Town & Country Planning Act 1990 (as amended)
Town & Country Planning (Tree Preservation) (England) Regulations 2012

Application for Works to Trees(s) subject to a Tree Preservation Order(TPO)

Development: To reduce 3 No. Maple Trees lateral branches, which are overhanging garage by 1.5 metres.
To reduce 1 No. Oak Tree lateral branches, in rear garden on right hand side by 1.7 metres.
The reason for the works is these are clearance of garage and patio area.

Location: 4 The Spinney Aldwick PO21 3RL

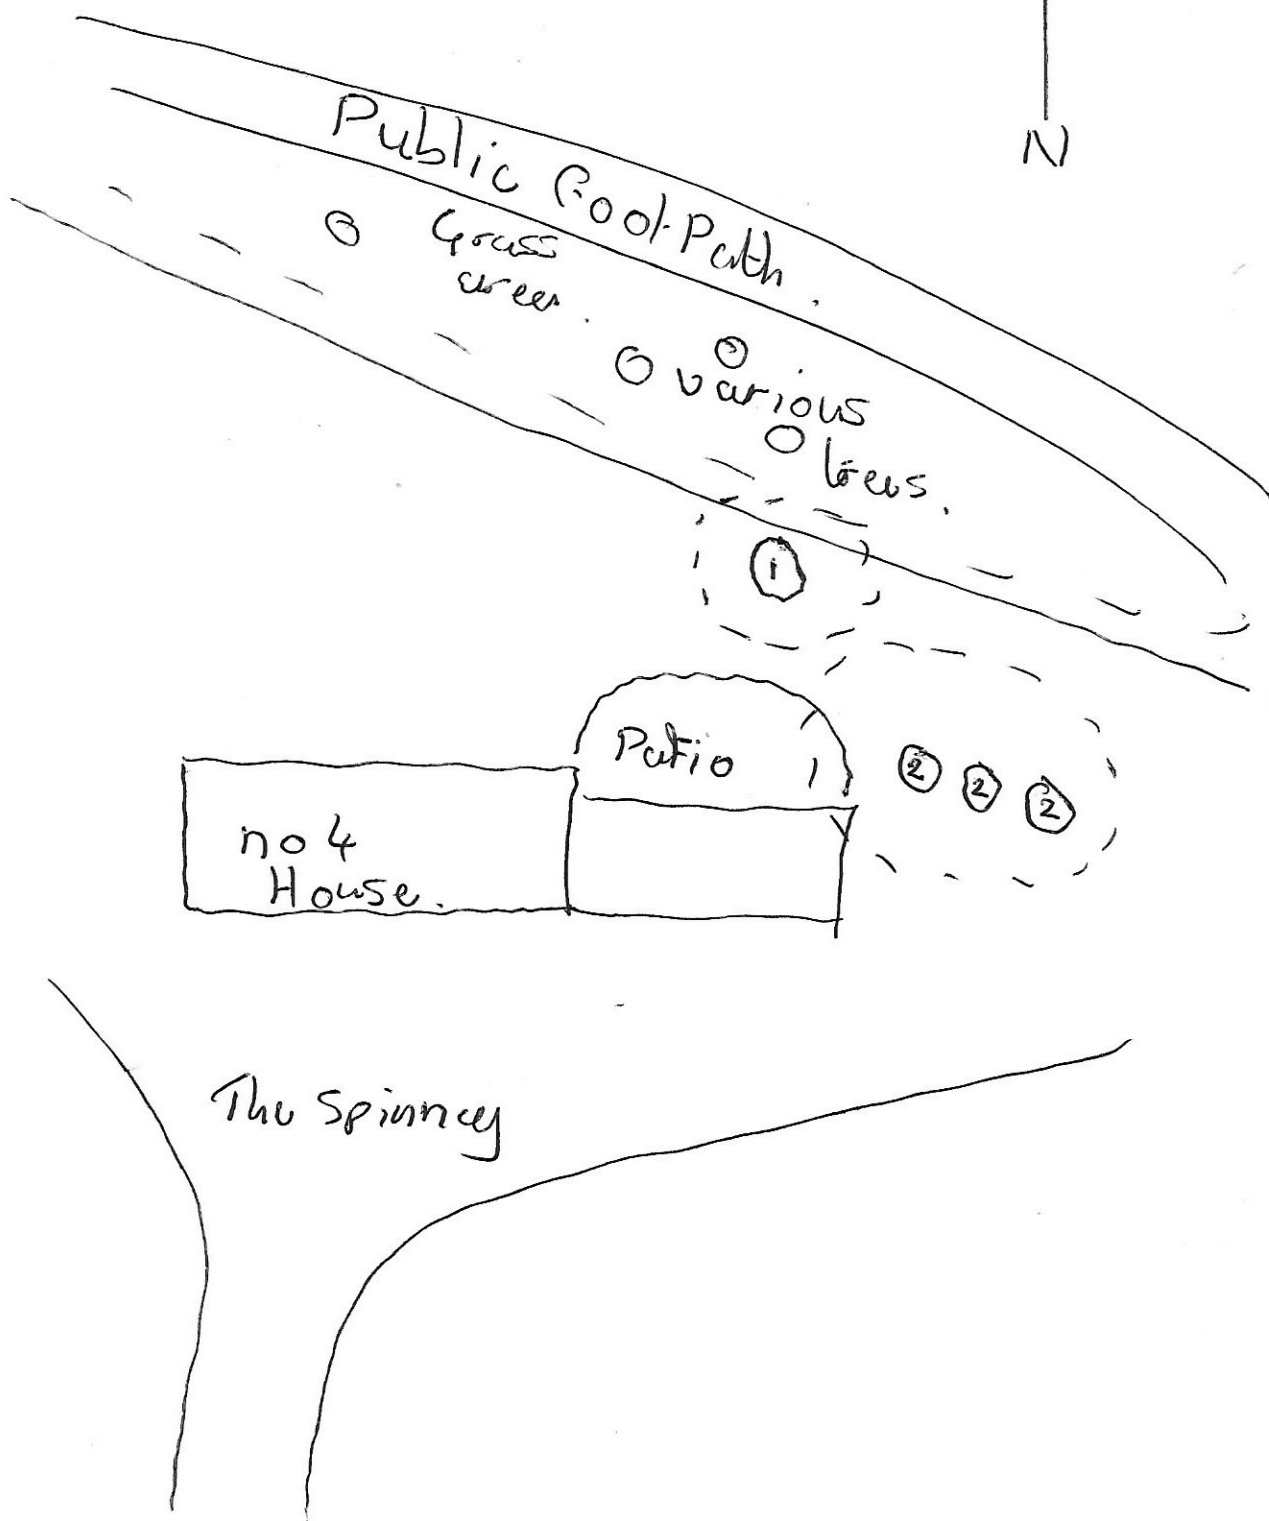
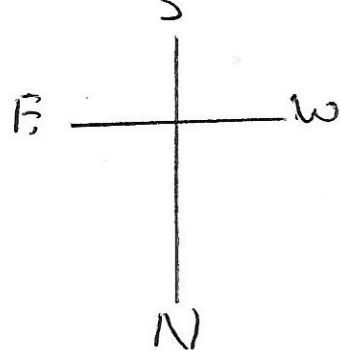
Please provide proposed spread measurements(m) of 3 No. Maple Trees and 1 No. Oak Tree and clarify location of trees on Sketch Plan provided.
